From: Chantelle Bashford <Chantelle.Bashford@arun.gov.uk>
Sent: 18 June 2020 10:14
To: Planning.Responses <Planning.Responses@arun.gov.uk>
Subject: RE: Planning Consultation on: BR/108/20/PL

Application No: BR/108/20/PL

Site Address: 74 London Road Bognor Regis PO21 1DD

Description of Works: Construction of 1 No. new second floor 2 bedroom flat over existing two storey building, additional bedroom to first floor flat, division of ground floor retail unit into 2 No units & change of use of ground floor retail space to form new access to second floor flat. This application may affect the setting of a listed building.

PROJECT	London Road	DATE	12/05/20
TITLE	Proposed Plans	DRG NO	IBA/532/03
SCALE	1 : 100	REVISIONS	A

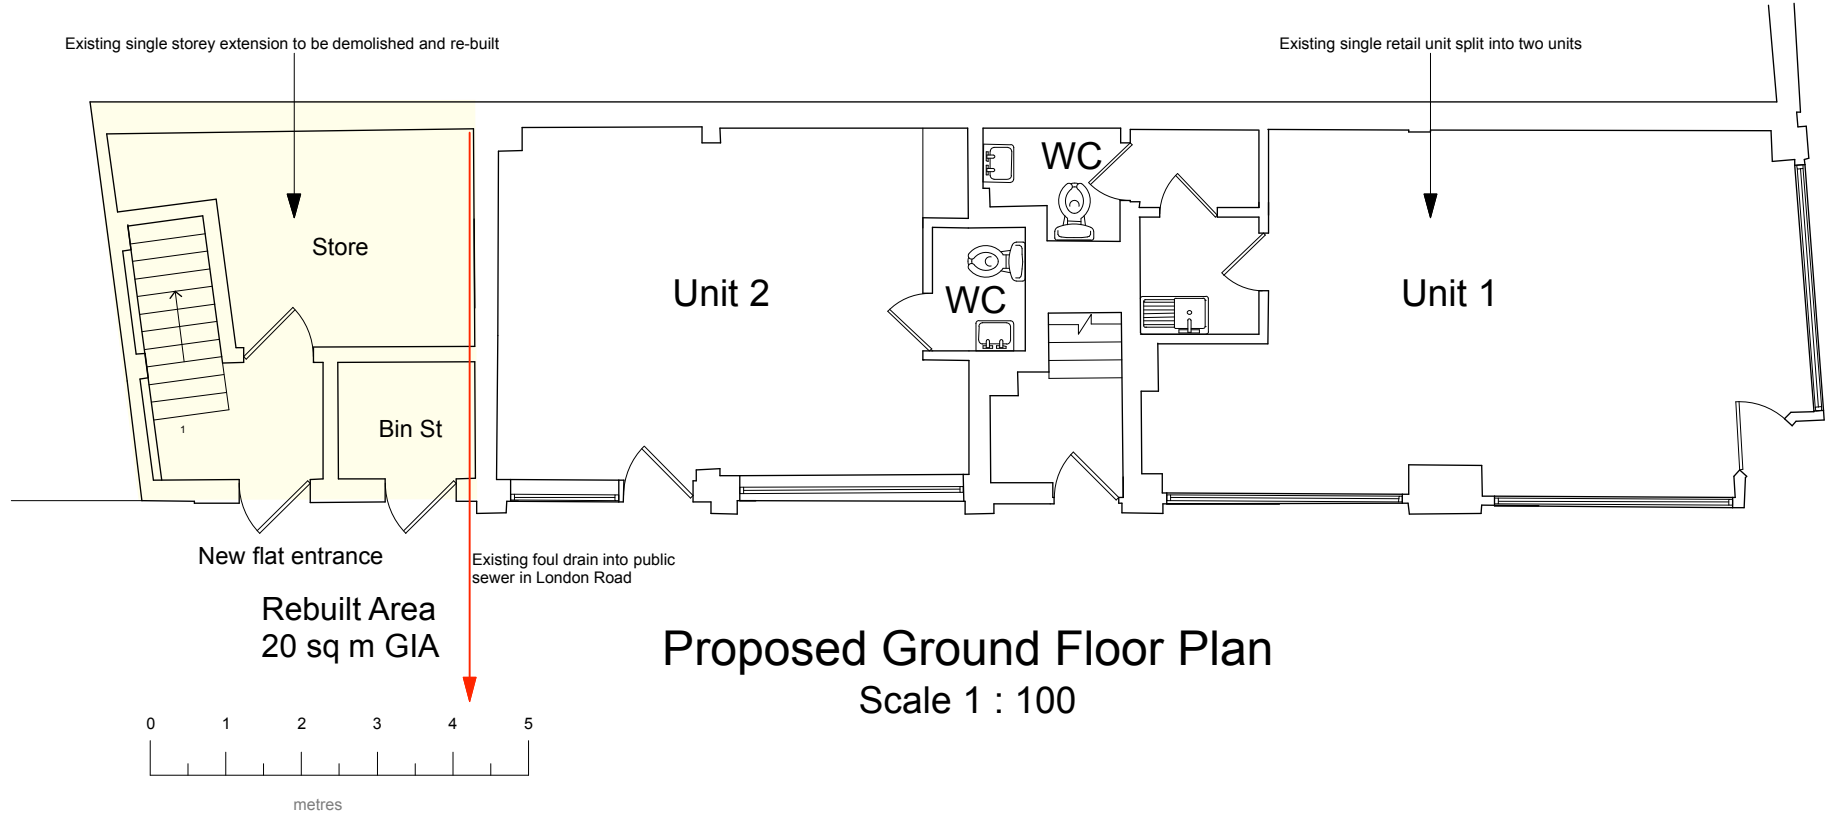
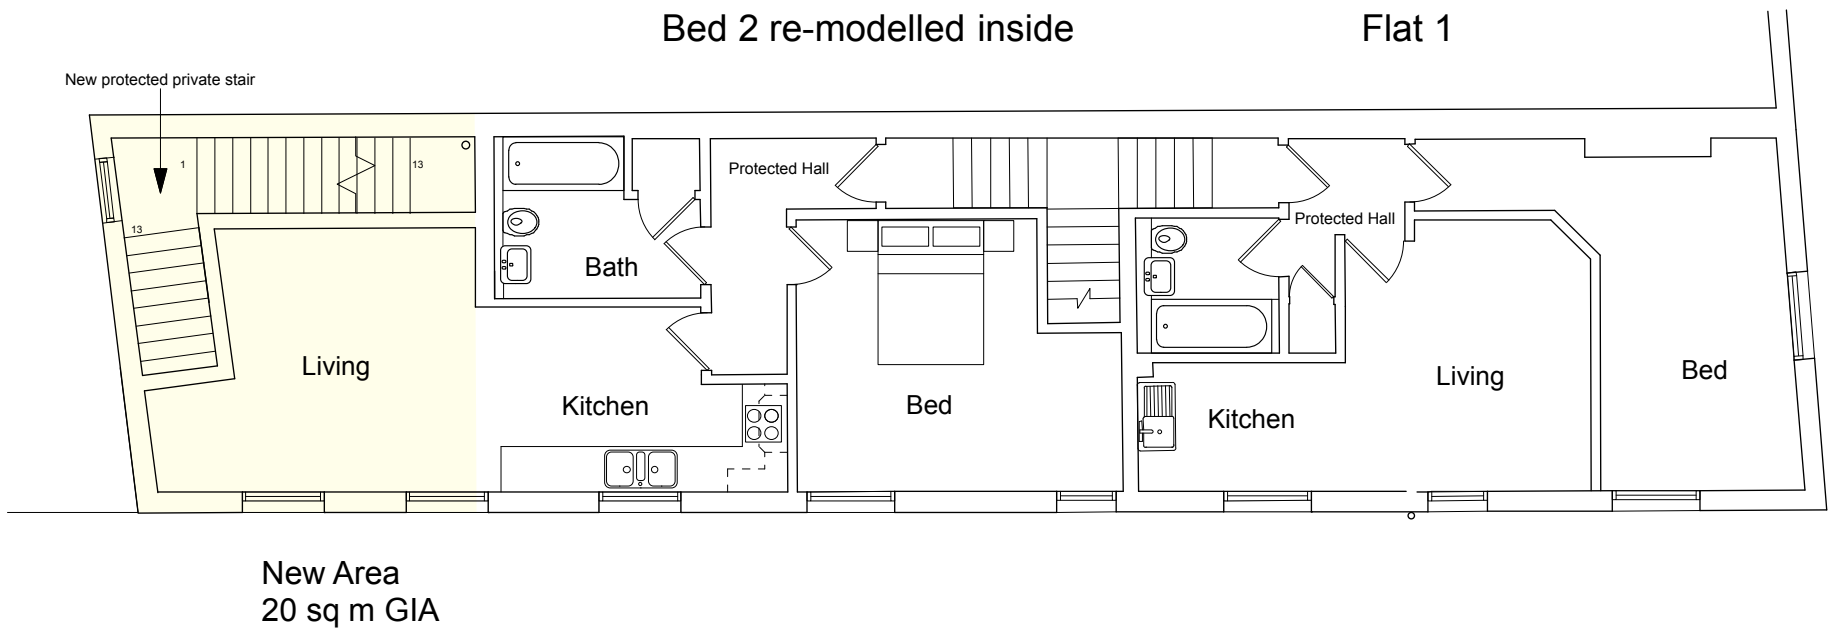
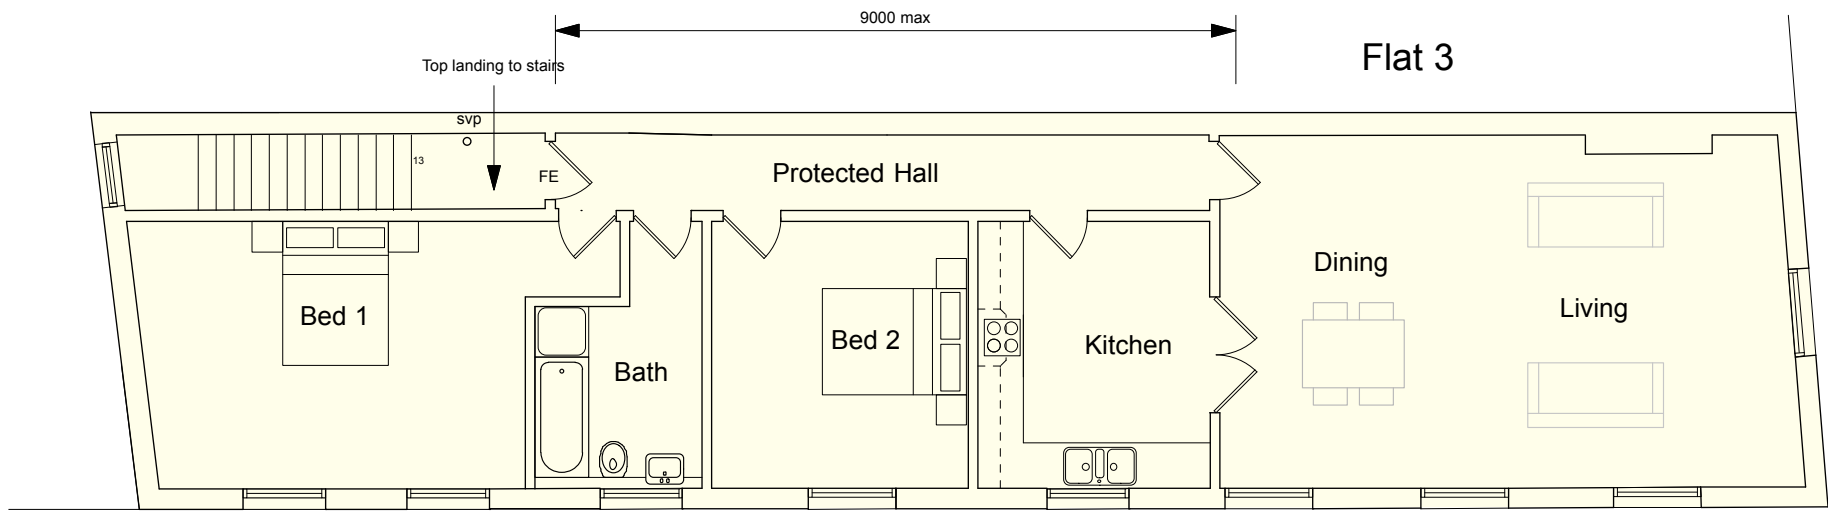
- Appropriate fire precaution facilities and equipment must be provided of such type, number and location as are considered necessary. Guidance on fire safety is contained in the LACORS guidance document – “Housing – Fire Safety, Guidance on fire safety precautions for certain types of existing housing”
- There should be adequate 60 minute fire separation between the commercial units on the ground floor and the residential flats above
- 30 minute fire resisting escape routes, which would include providing a 30 minute fire resisting and self-closing fire door (FD30S) to each internal flat entrance
- Bin store to afford 30 minutes fire resistance to protect the escape route
- Store room to ground floor to afford 30 minutes fire resistance to protect the escape route
- A mixed Grade A, LD2 and Grade D1, LD3 fire system should be maintained and installed

- Interlinked detection throughout the escape routes
- Interlinked detection to each retail unit
- Interlinked detection to the ground floor store room if a source of ignition is present
- Interlinked heat detection to each flat

- Non-interlinked mains-wired smoke alarms with integral tamper-proof battery back-up to each flat

N.B. The Fire Risk Assessor may recommend interlinked detection is also installed in the bin store as this is a potential arson target given that the property is located within the town centre

- Emergency lighting may be required to both escape routes due to the lack of borrowed light throughout

- Kitchens should have adequate mechanical ventilation
- Mechanical extraction should be provided to all bathrooms/shower rooms/en suites

- Must meet the requirements of the Housing Act 2004 and be free of Category 1 and significant Category 2 Hazards
- Flat 3 has the potential to operate as a House/Flat in Multiple Occupation (HMO), depending on how it is occupied. If the flat becomes an HMO, it must;
 - Meet the requirements of the Arun District Council Houses in Multiple Occupation Standards (2020)
 - Meet the requirements of any other associated Housing and/or Houses in Multiple Occupation legislation or regulations if applicable to the property/site
